Technical Memorandum

Date:	October 5, 2023	Project Manager:	Jeffrey P. Laub, P.E., L.G., L.E.G.
To:	Brad and Judy Chase 4467 Forest Avenue SE Mercer Island, Washington 98040	Principal in Charge:	Bruce L. Blyton, P.E.
cc:	Ms. Patricia Flores, Olson Kundig	Project Name:	Chase (Fused Elements) Residence
Address:	patricia@olsonkundig.com	Project No:	20220141E001
Subject:	Steep Slope Plantings

TREE REPLACEMENT PLAN

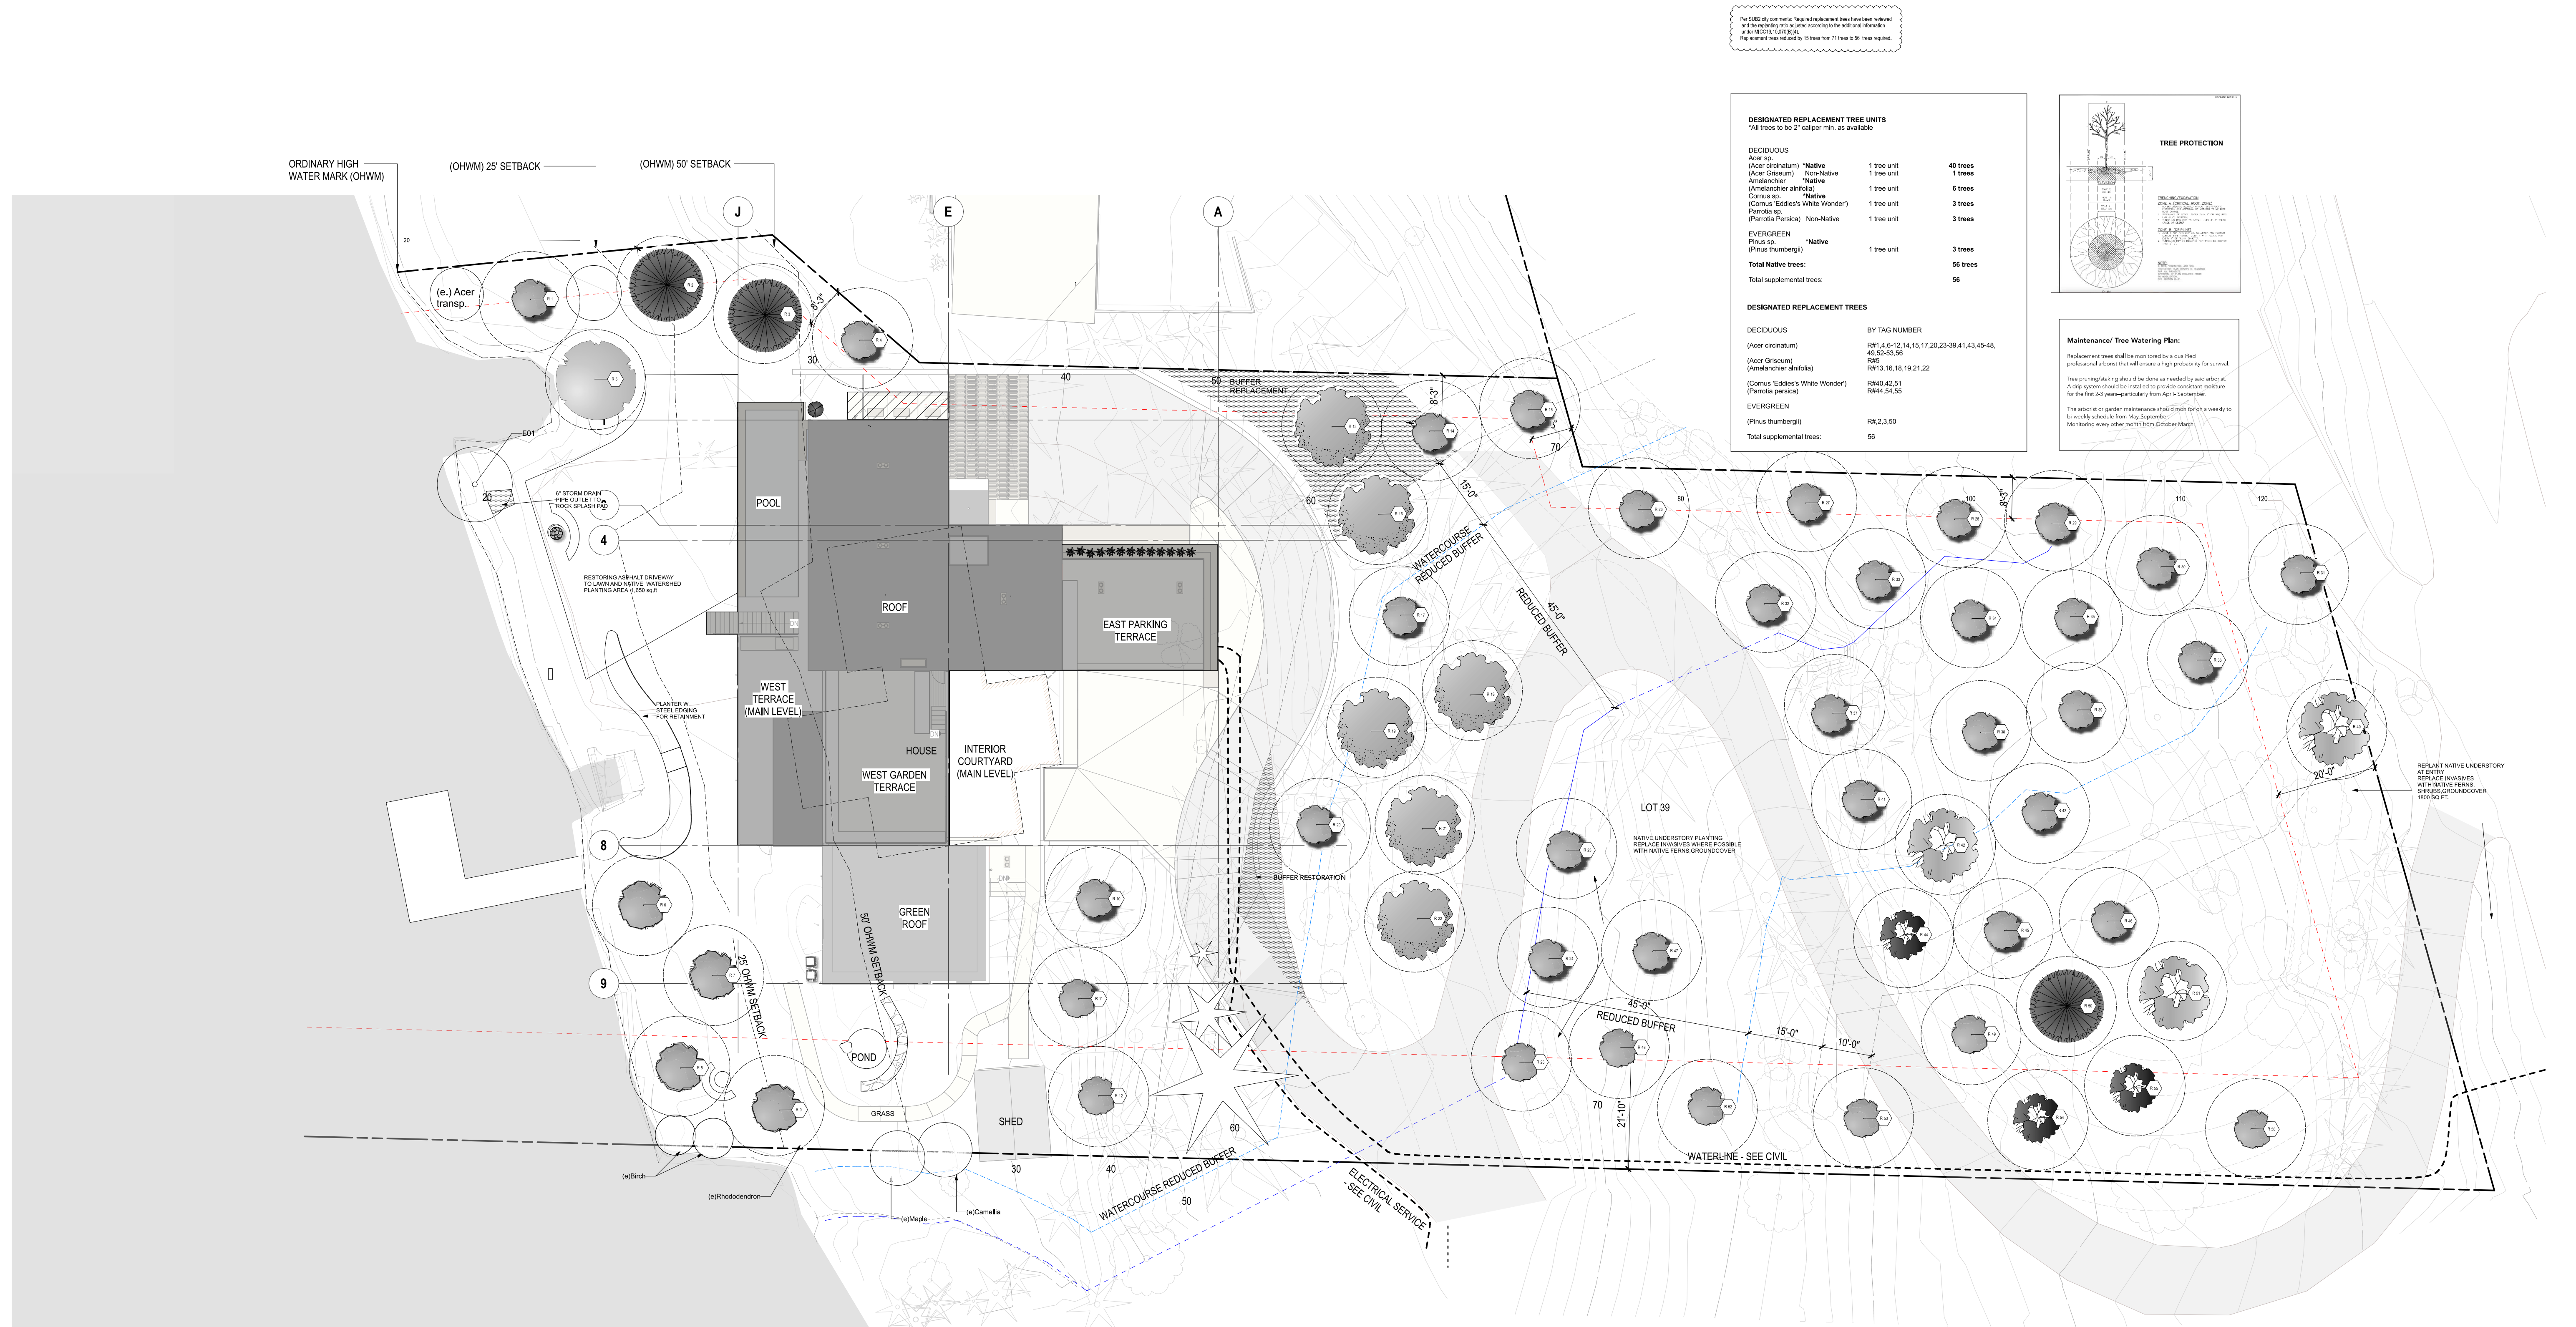
Based on our review of Sheet L1.01 ("Tree Replacement Plan"), prepared by Spring Greenworks and dated September 8, 2023, we understand that the proposed plantings include twenty-nine, two-inch-caliper trees. Based on our observations and review of this plan, it is our opinion that the proposed plantings should not represent a significant adverse impact to slope stability. We recommend that excavation for tree placement be completed with hand tools, and that the surrounding vegetation/ground cover be left in place to provide a measure of local support to surface soils and mitigate impacts associated with ground disturbance. We also recommend that disturbed ground be prepared, mulched, and replanted as soon as possible to mitigate erosion, and that irrigation of the vegetation be limited to prevent excessive saturation of sloping ground and potential soil movement.
